**WELWYN HATFIELD BOROUGH COUNCIL
ASSISTANT DIRECTOR (PLANNING)**

DELEGATED APPLICATION

Application No: 6/2023/2036/HOUSE
Location: Wing 2 Warren Wood Kentish Lane Hatfield AL9 6JQ
Proposal: Erection of front portico with alterations to fenestration, detached granny annexe, detached garage and hard and soft landscaping works following the demolition of existing front extension and outbuildings
Officer: Ms Elizabeth Mugova

Recommendation: Refused

NO.	REVISION	DATE	PROJECT	TITLE
			WINGS 2, WARREN WOOD PARK, BROCKMANS PARK	PROPOSED GRANNY ANNEXE & GARAGE PLANS, ELEVATIONS & COMPUTER GENERATED IMAGES
CLIENT			PRIVATE CLIENT	DRAWING STATUS
SCALE			1:100	PLANNING
SHEET			A1	DRAWING REF.
DATE			JUNE 23	REV.
			007

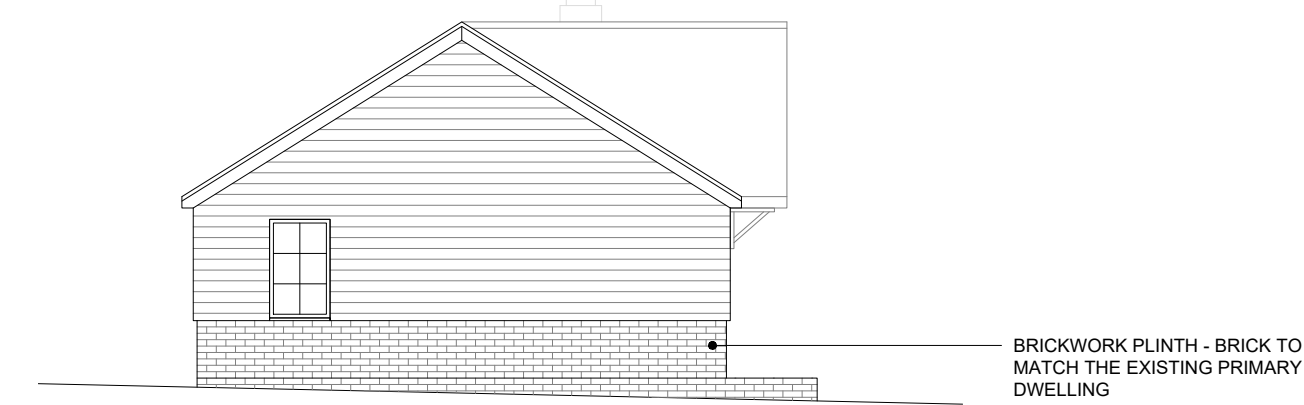
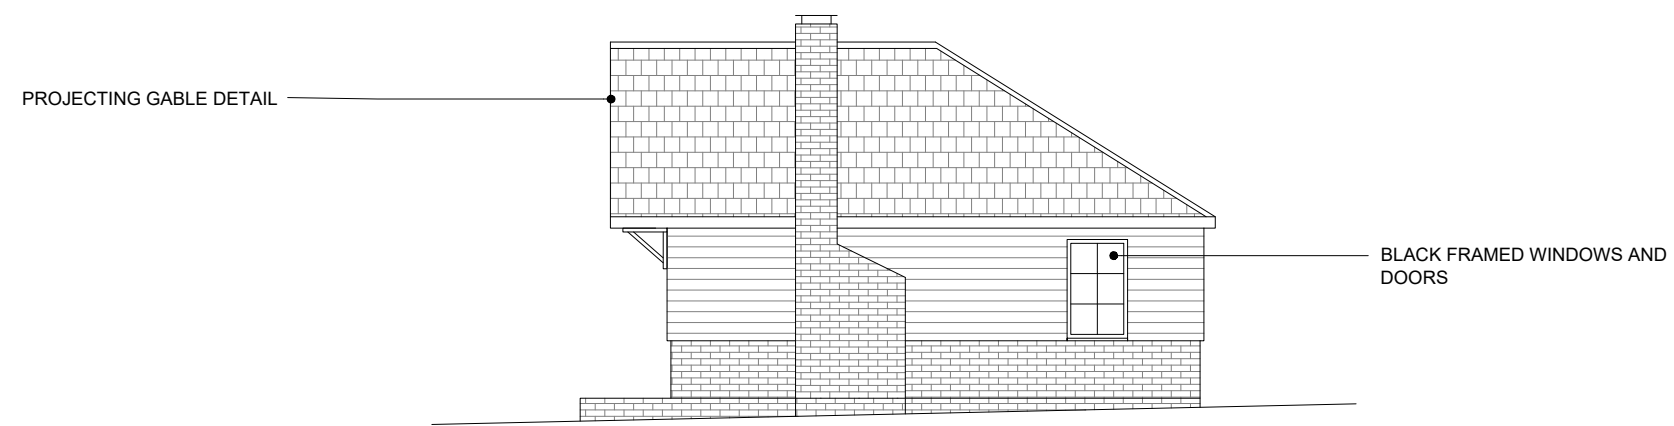
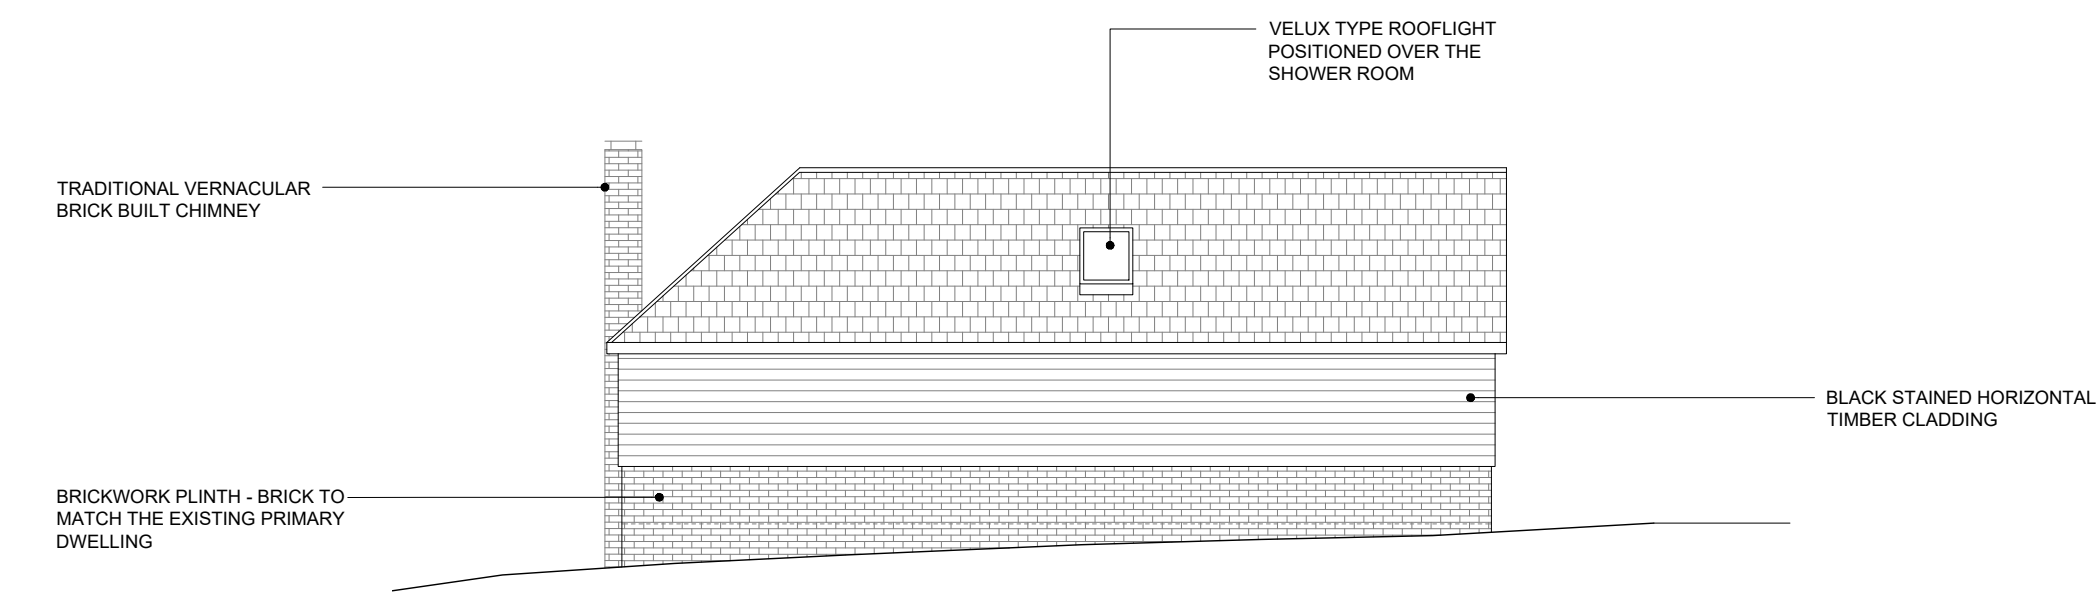
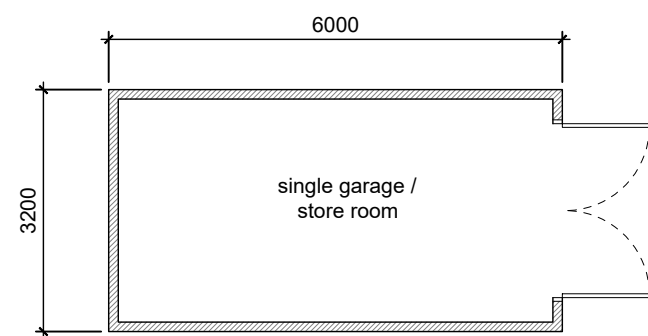
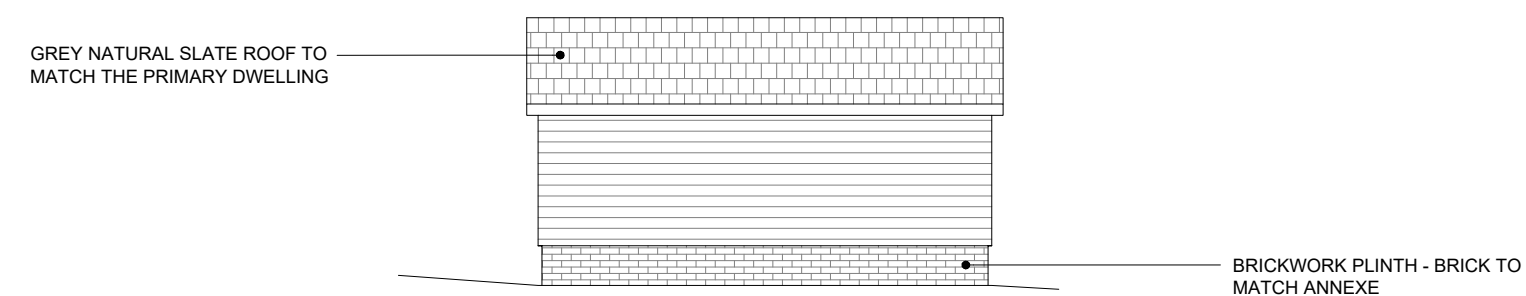
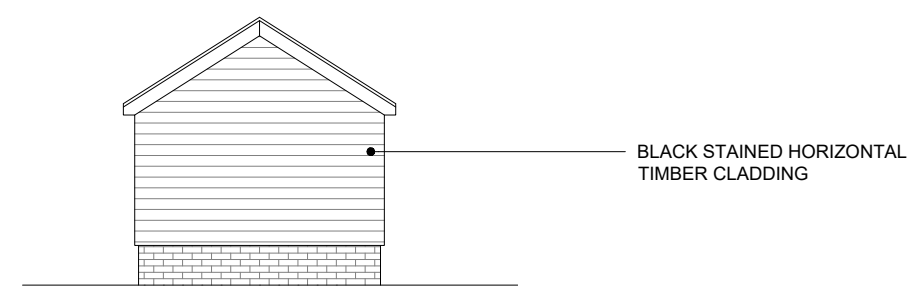
The proposed granny annexe and garage would be substantially larger than the two existing buildings which it would replace in terms of their scale, volume and footprint, with the result that the

proposed building form would have a greater impact on the openness of the Green Belt to the existing. In addition, they would facilitate a materially different level of activity to that of the existing buildings. This is because unlike the existing buildings the proposed granny annexe would permit the residential occupation of the annexe, as well as this part of the site, including its associated garden, both during the day but also at the evening and at nighttime. This use would therefore be materially different from the existing use, and type of activity within this part of the site to that which currently exists. Furthermore, due to the design and the proposed fenestration detailing of the building the impact of this change would be exacerbated at in the evening and nighttime when the building would be internally, and potentially externally, illuminated with the result that there would be light spillage from the building out into the site, as well as the wider countryside. In addition, the proposed change of use of the other land discussed above which has not previously been granted planning permission to be used in association with the application property would result in a further loss openness of the Green Belt because it would allow for the spread of residential paraphernalia into this area.

terraced properties. Although the detailed design the proposed granny annexe and garage would appear well balanced, due to the siting of the proposal, it would be the first building viewed on the approach to the host dwelling and it would be dominant and overly prominent. As such, the proposal would result in a significant departure from the prevailing character and wider pattern of development within the surrounding area.

The proposed granny annexe and the garage would be physically detached from the host property (approx. 40m away from the front elevation) and would be sited within an area enclosed by an existing hedge. Its scale, layout and design of these buildings mean that they would have the appearance of modest dwelling, with an associated garden and garage. In addition, for the reasons discussed already in this report the proposed annexe would not fall within the permitted residential use of the application dwelling and it is considered that it would be outside the residential curtilage of the dwelling within the site. Furthermore, although the annexe and host dwelling would share vehicular access route from Kentish Lane, it is unclear from the submitted details what else they would share as the proposed granny annexe would have its own garden, garage and all the facilities required for independent living. In addition, whilst they would share an access, due to the positioning of the granny annexe within the site, the sharing of this access would be more akin to that of an access shared by independent dwellings instead of a building with an ancillary use to the primary use of the site.

As a result, it is not considered that the proposed granny annexe, and its garage, would have a clear functional link with the existing dwelling on the site. This is because for the reasons discussed the granny annexe and main dwelling would be physically and functionally separate, with the granny annexe being outside the residential curtilage of the main dwelling and outside the permitted residential plot for this dwelling. As a result, the proposed granny would be capable of being lived in, in a manner entirely separate from the existing dwelling on the site.

2. By virtue of the use, scale, layout, design and siting of the proposed granny annexe and garage they would have an adverse impact upon the character and appearance of the site and surrounding landscape. The proposal therefore fails to comply with Policies SP1, SP9 and SADM16 of the Welwyn Hatfield Borough Council Local Plan; Supplementary Design Guidance; and the National Planning Policy Framework.
